60A Danforth St  
WPD Zone

## MEMORANDUM

**Subject:** Response to DeLuca-Hoffman Comments  
Merrill Industries – Rubb #7  
Site Location Application

EROSION CONTROL PLAN
 OF
MERRILL'S MARINE TERMINAL
 601A DANFORTH STREET
 PORTLAND, ME
 FOR
MERRILL INDUSTRIES
 114 EBEN HILL ROAD
 YARMOUTH, ME 04096

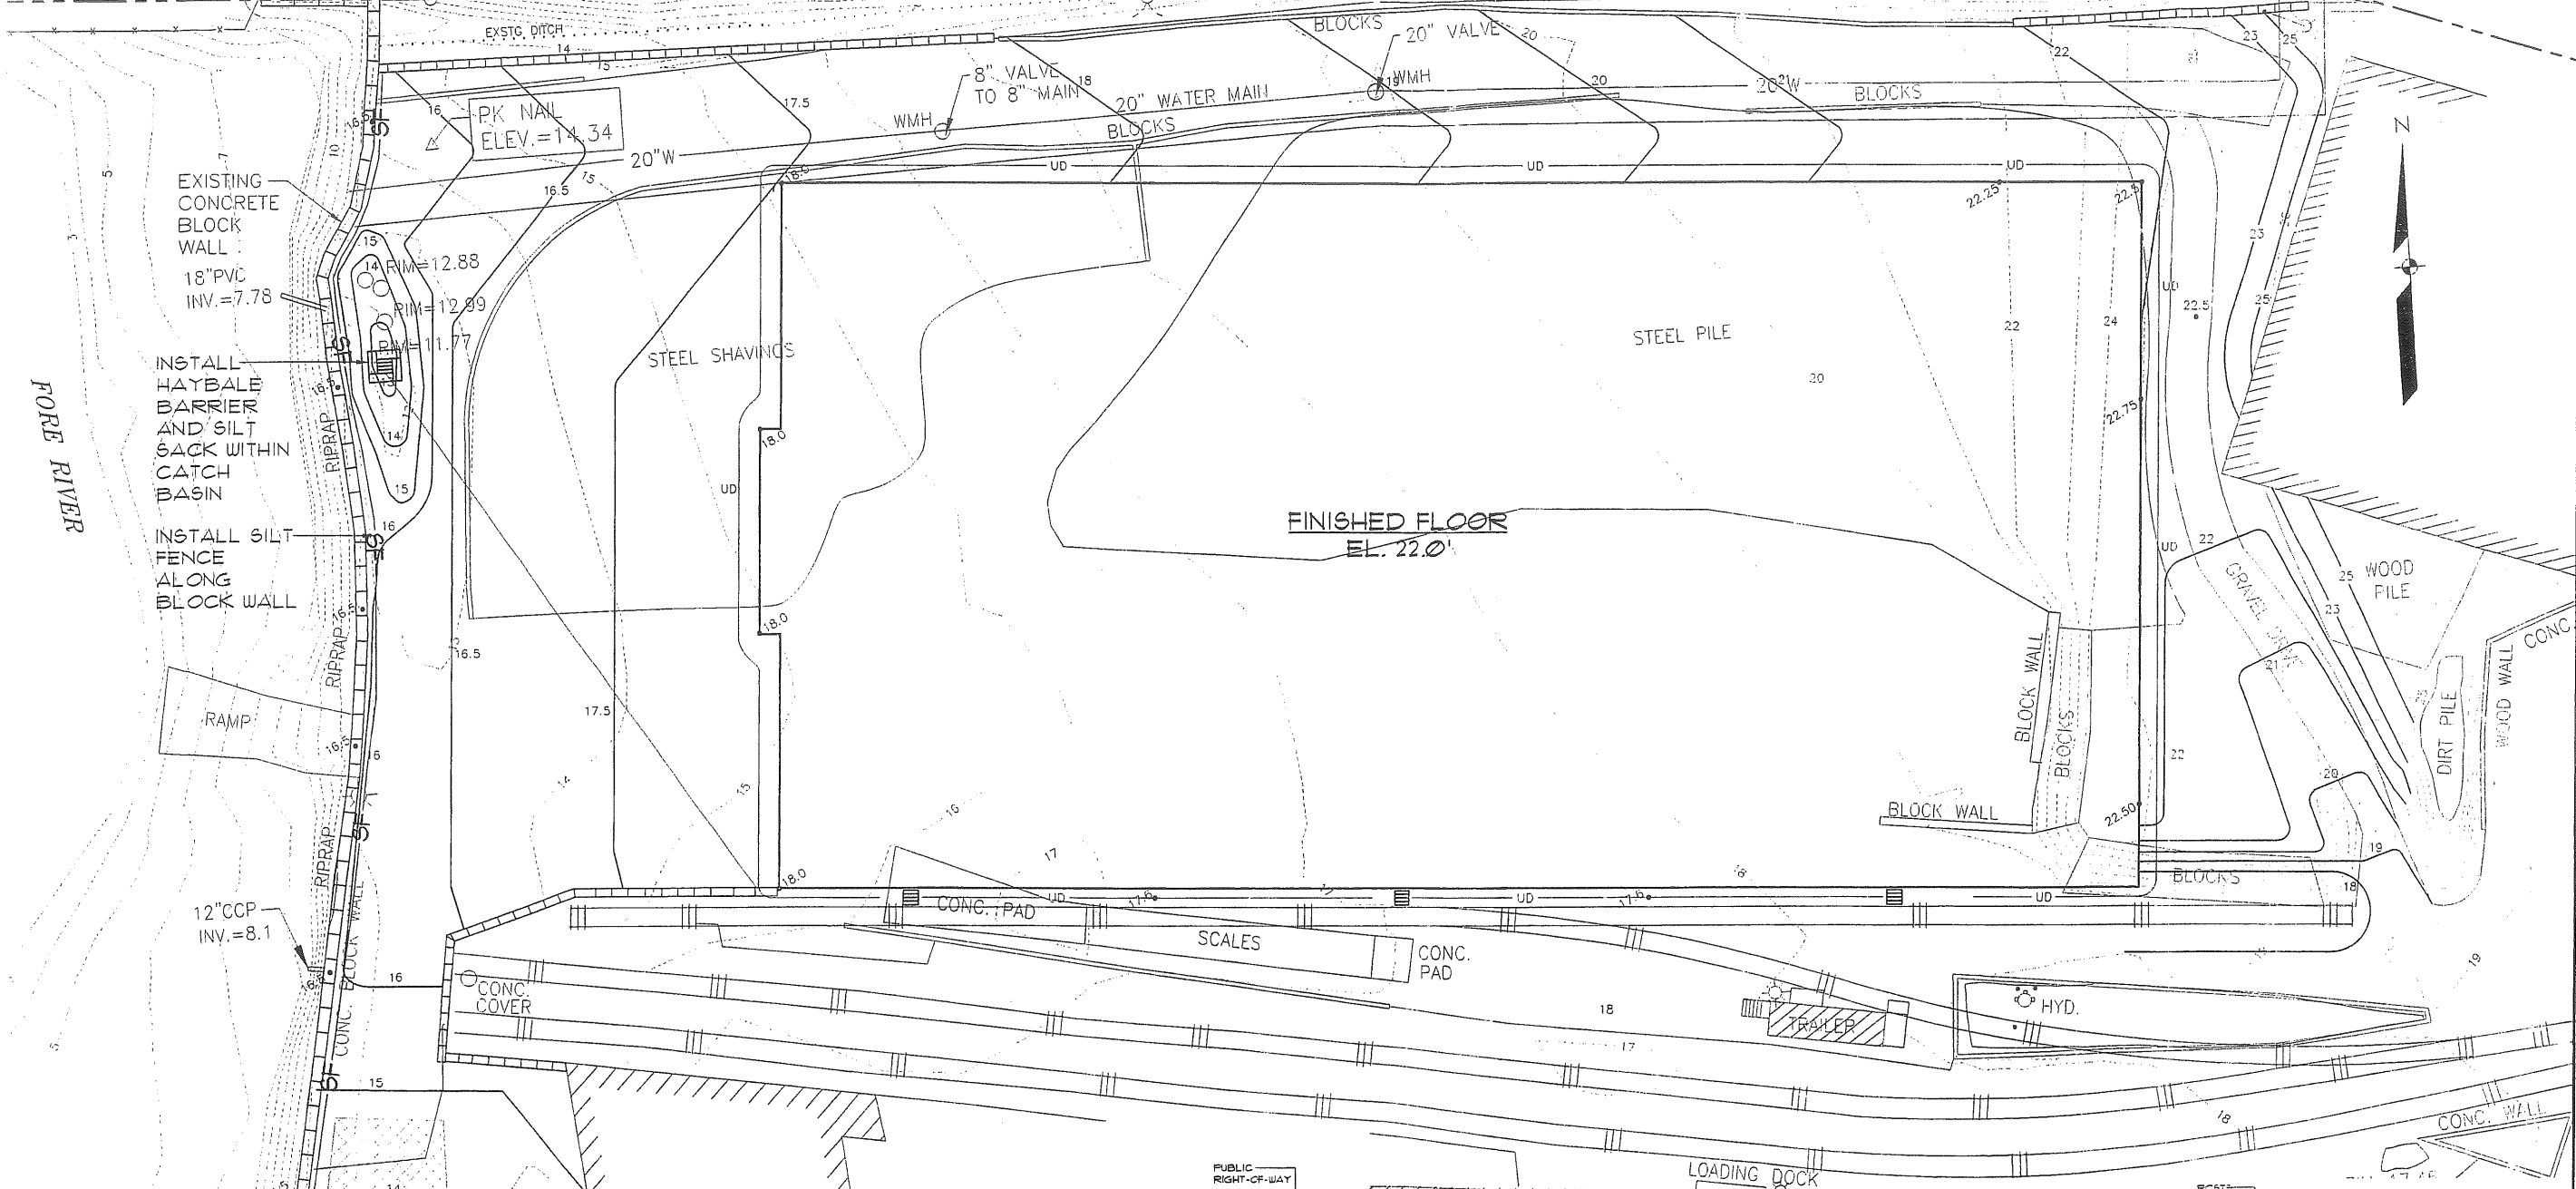
**Item 3i** – An Erosion/Sedimentation Control Plan has been developed for the site by STI. This drawing is enclosed.
